REQUEST

Current Zoning: CG (general commercial)
Proposed Zoning: MUDD-O (mixed use development district, optional)

Approximately 1.63 acres located along the northeast side of East 7th Street, south of Lamar Avenue, and north of Clement Avenue.

Staff does not recommend approval of this petition in its current form.

HEIGHT PLANE EXHIBITS

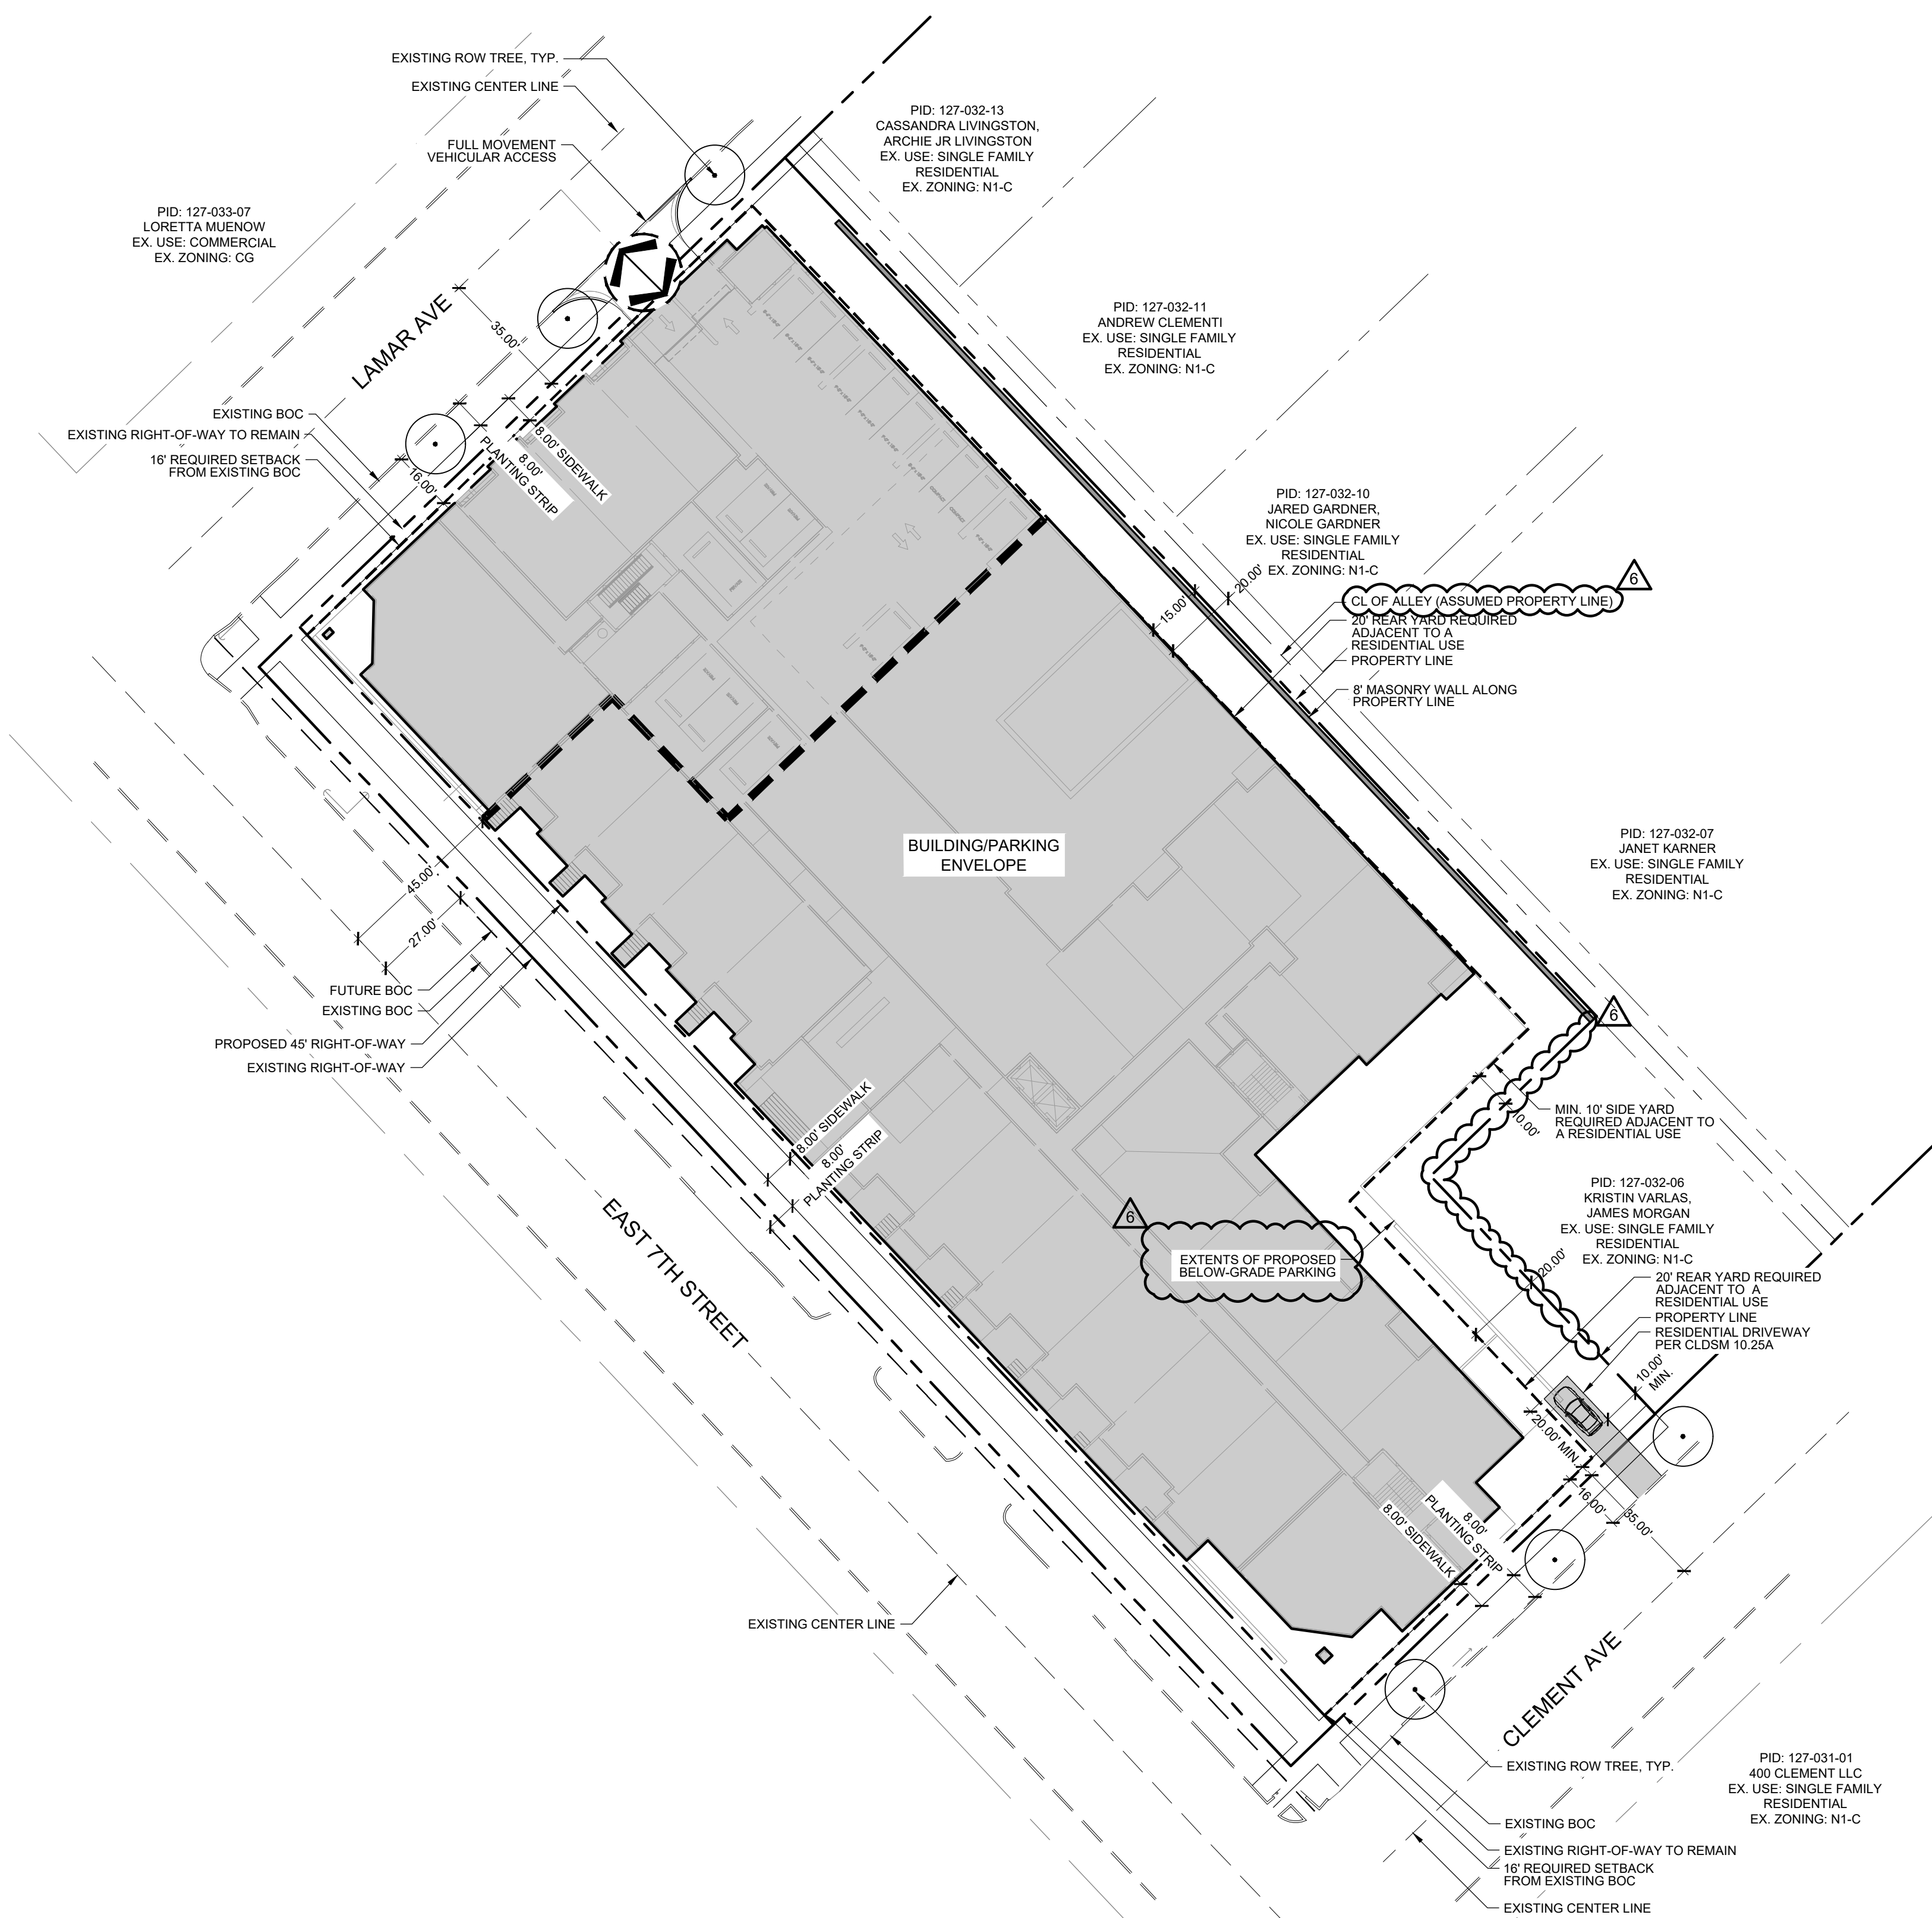
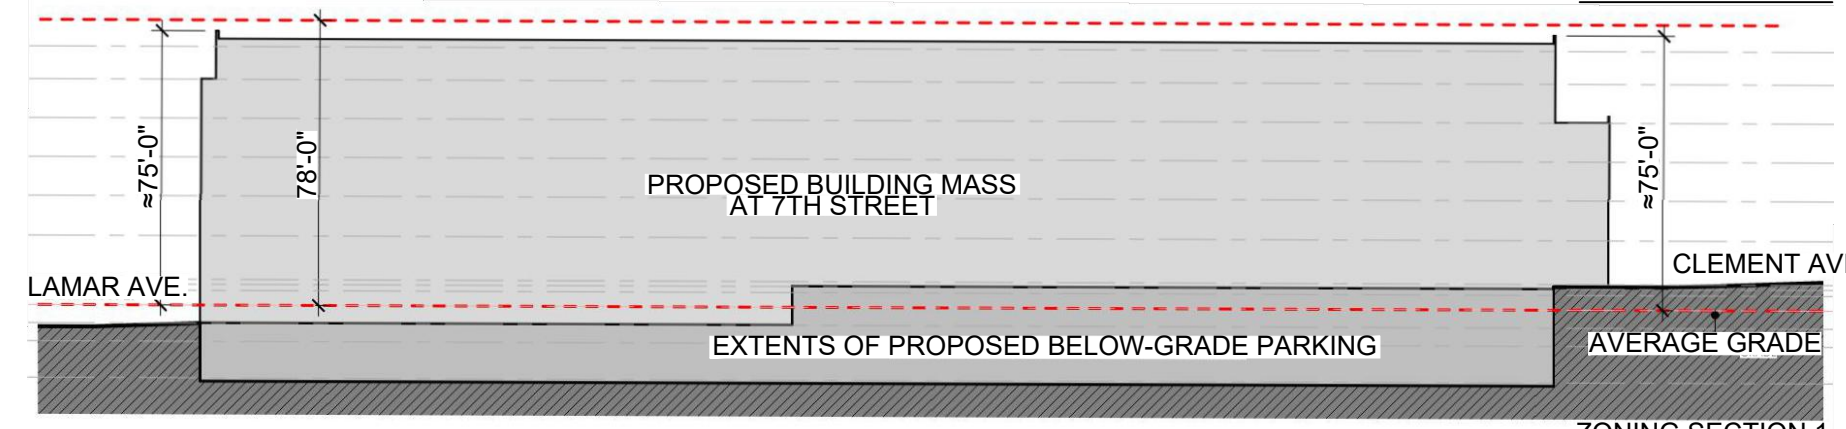
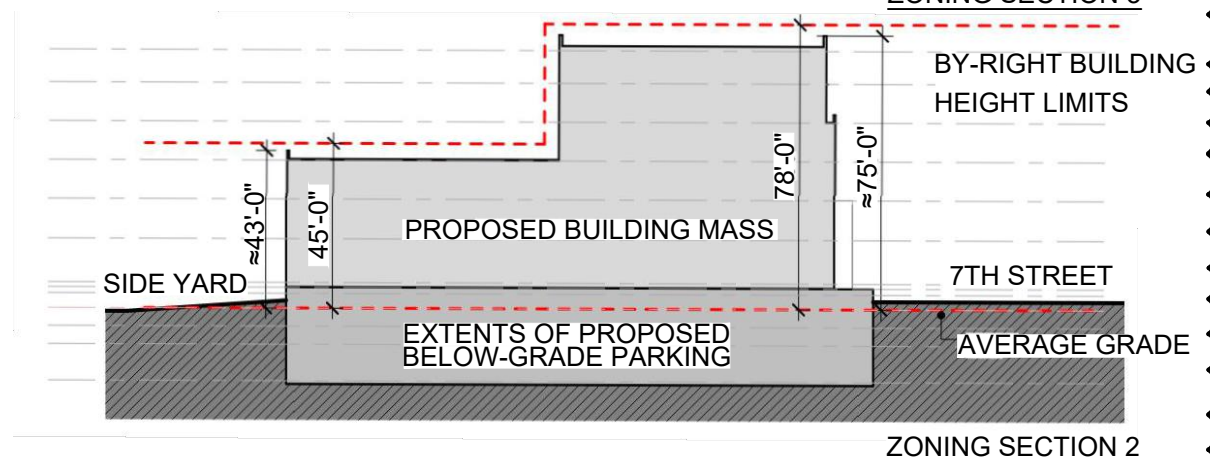
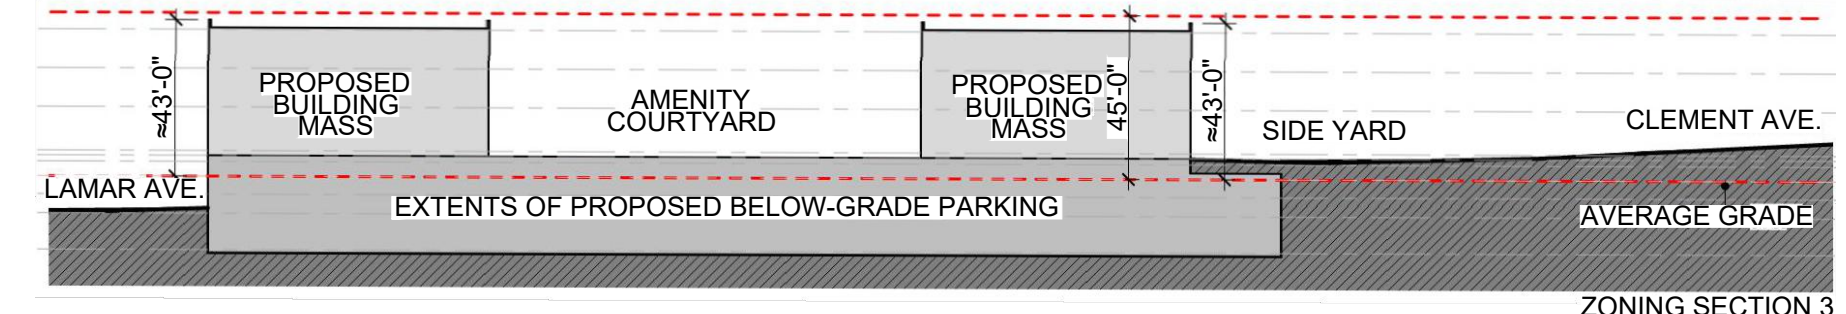
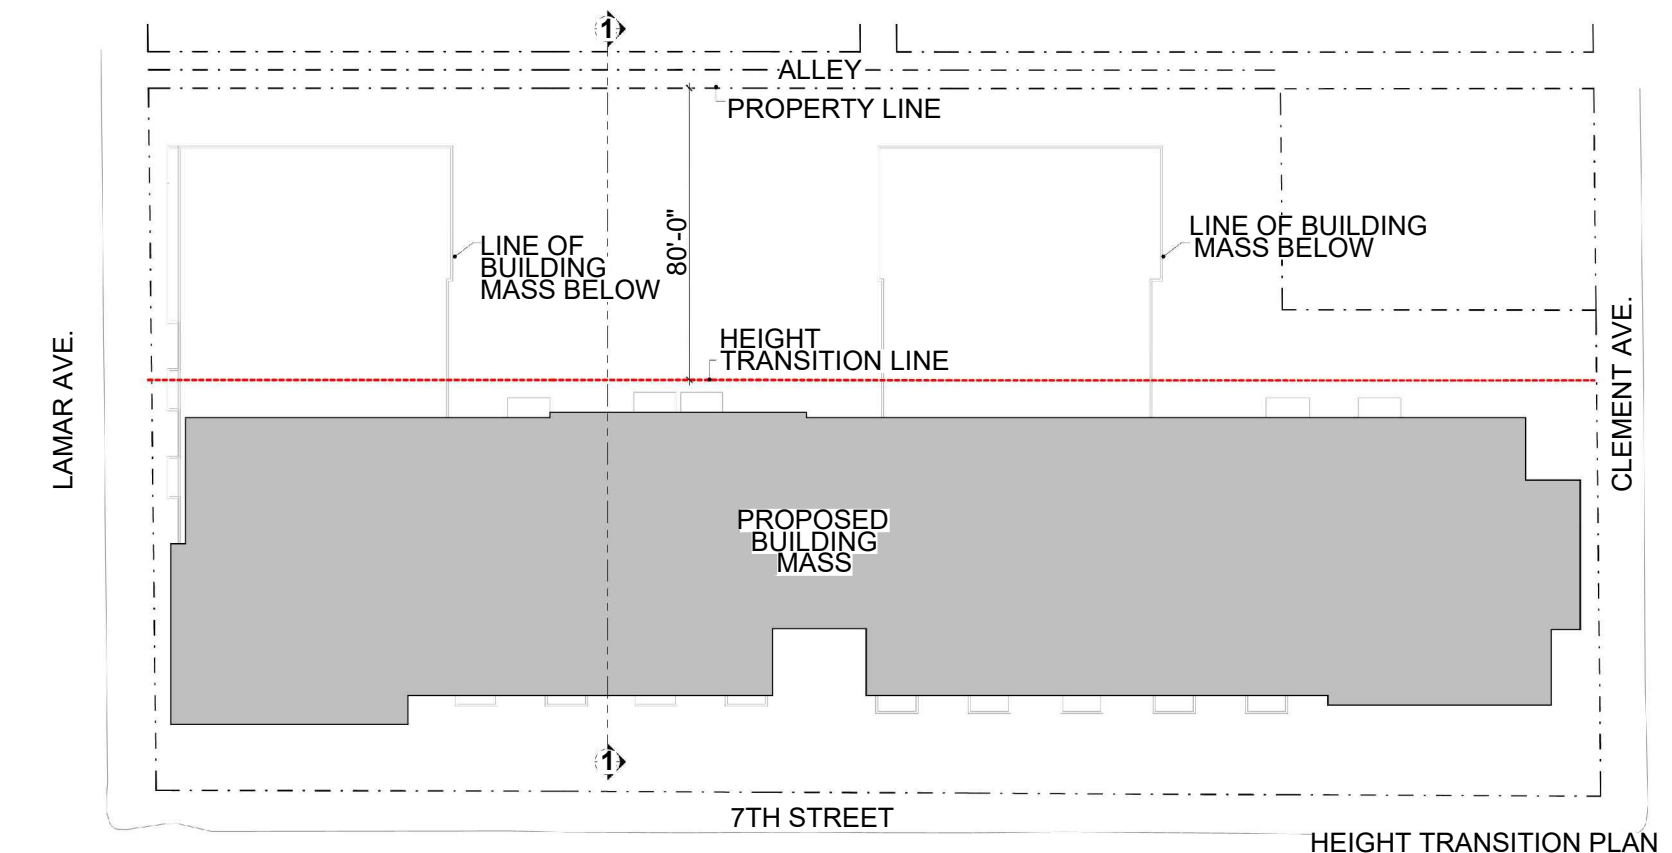
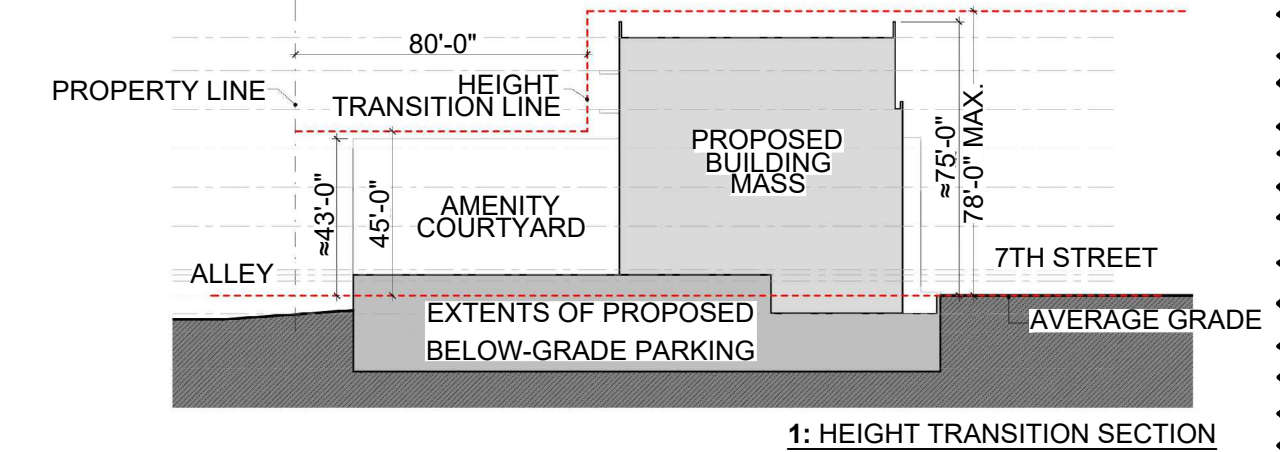
1. Reduce maximum building height to no more than 65' and detail in the conditional notes how the height steps down to the adjacent N1 areas by including a maximum height for the rear of the building and noting where the height stepdown occurs in terms of the number of feet away from the N1 areas. **Partially Addressed, See Note 5**

5. Reduce the maximum building height to 65' and revise the proposed height transition detailed in the height plane exhibits and conditional notes so that no portion of the proposed building exceeds 50' in height when located within 100' of property lines in the Neighborhood 1 Place Type.
-
